WEST SUSSEX COUNTY COUNCIL CONSULTATION

TO:	Arun District Council FAO: Obafemi Okusipe
FROM:	WSCC - Highways Authority
DATE:	9 May 2022
LOCATION:	73 Manning Road Littlehampton BN17 7HX
SUBJECT:	LU/113/22/LU Removal of double garages and provision of 1 No detached 2 bedroom 4 person dwelling. This site is in CIL Zone 4 and is CIL Liable as new dwelling.
DATE OF SITE VISIT:	n/a
RECOMMENDATION:	Advice
S106 CONTRIBUTION TOTAL:	n/a

Proposed Block & Site Plan

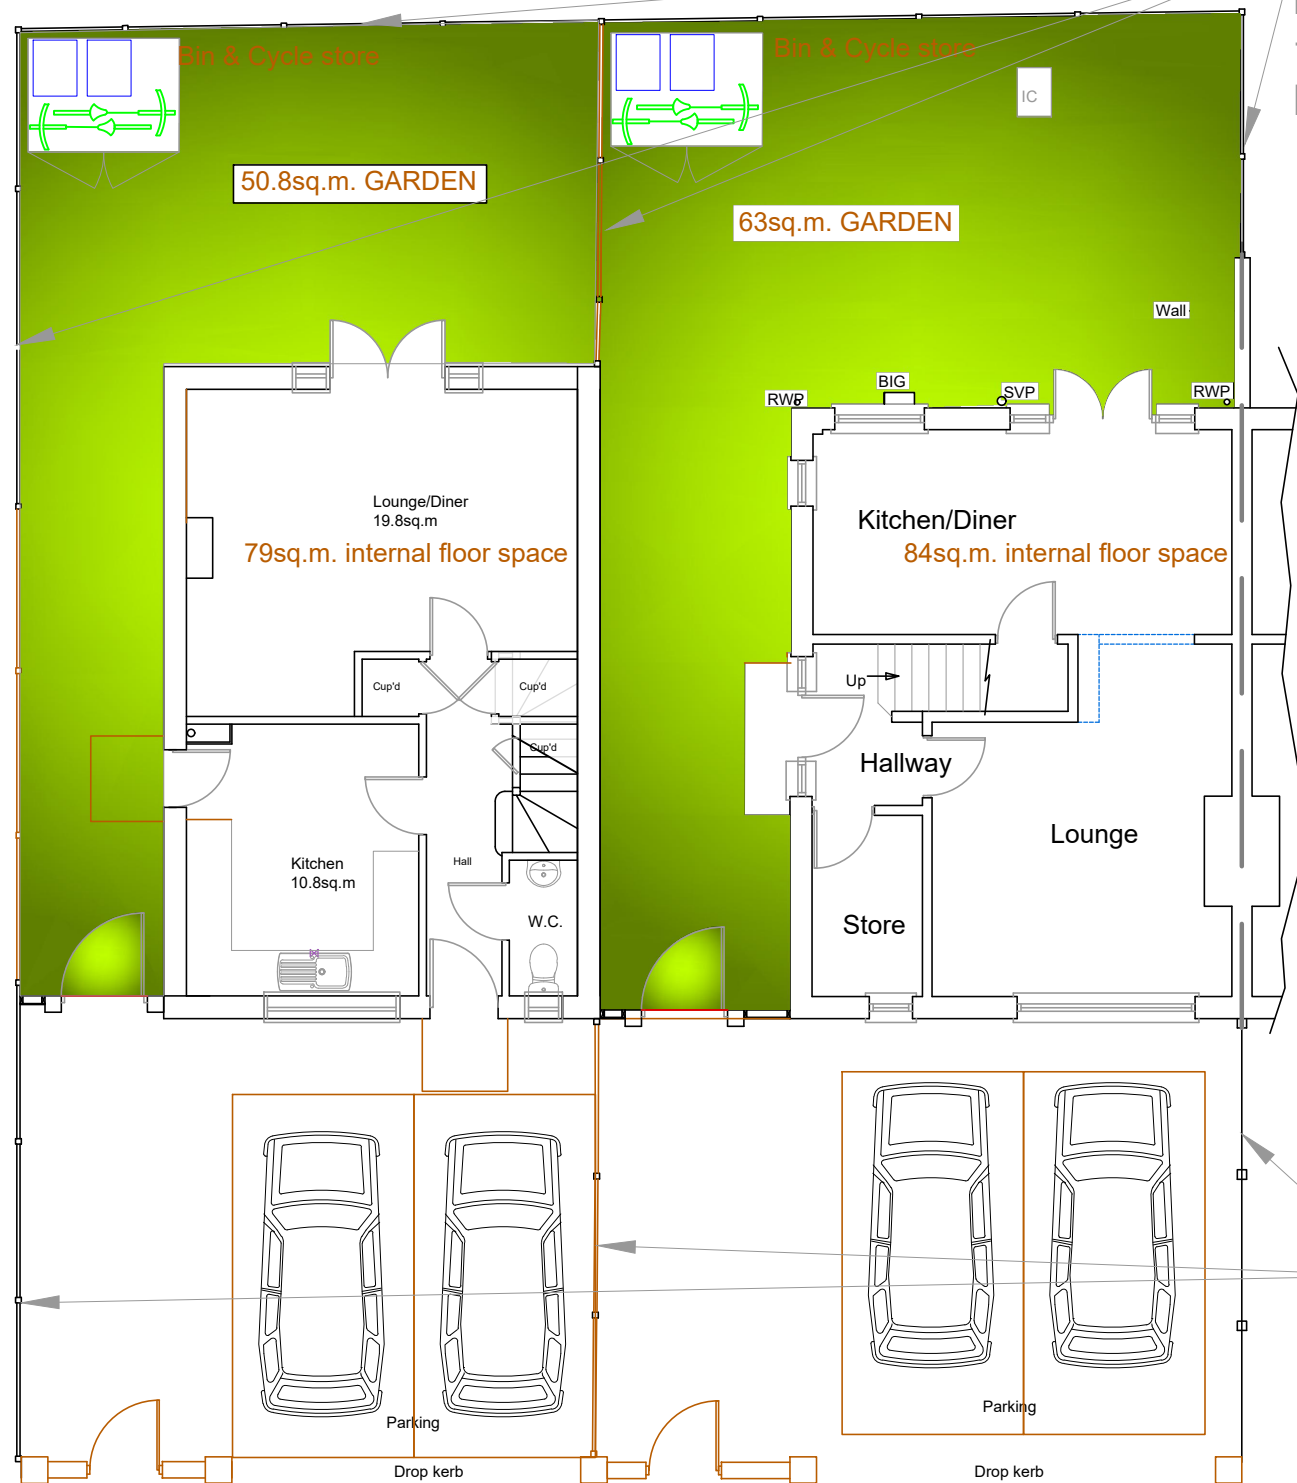
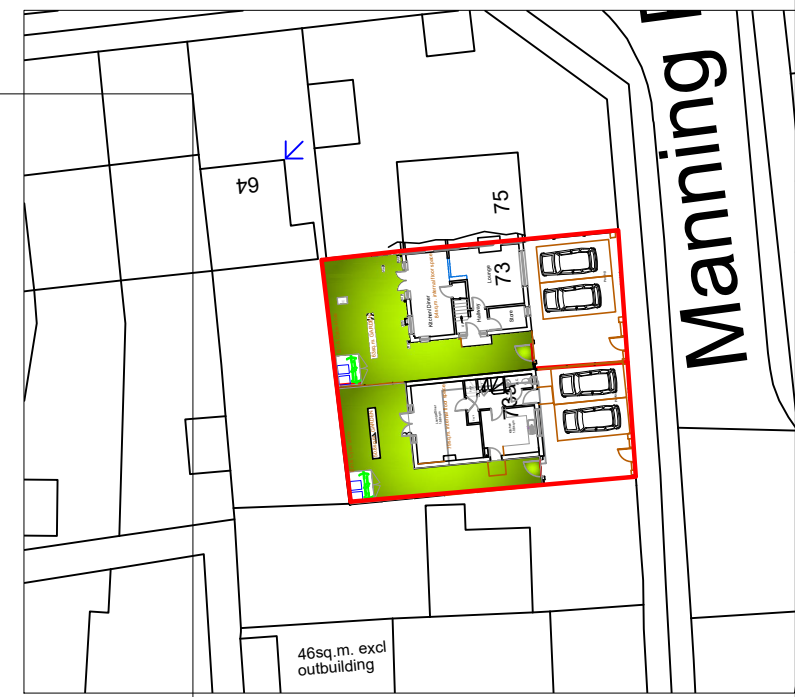
The applicant has stated that they intend to provide a new access point (VCO). No details of the kerbside measurements have been provided. Such details can be secured via a suitably worded condition, found below.

The applicant proposes to remove the existing garage, which under Arun Guidance is anticipated to provide 1 parking space alongside cycle parking.

The hardstand for the 'Right' property measures 5.2 x 5 metres.

The hardstand for the 'Left' property measures 4.6 x 4.8 metres.

The LHA advises the applicant investigates the parking provision using both Arun's Parking Guidance and WSCC Area Office License guidance.

The applicant has provided cycle parking, the LPA may wish to secure such details with a suitably worded condition.

The use of the car parking space(s) shall not commence until the vehicular access has been constructed in accordance with plans and details **to be** submitted to and approved in writing by the Local Planning Authority.
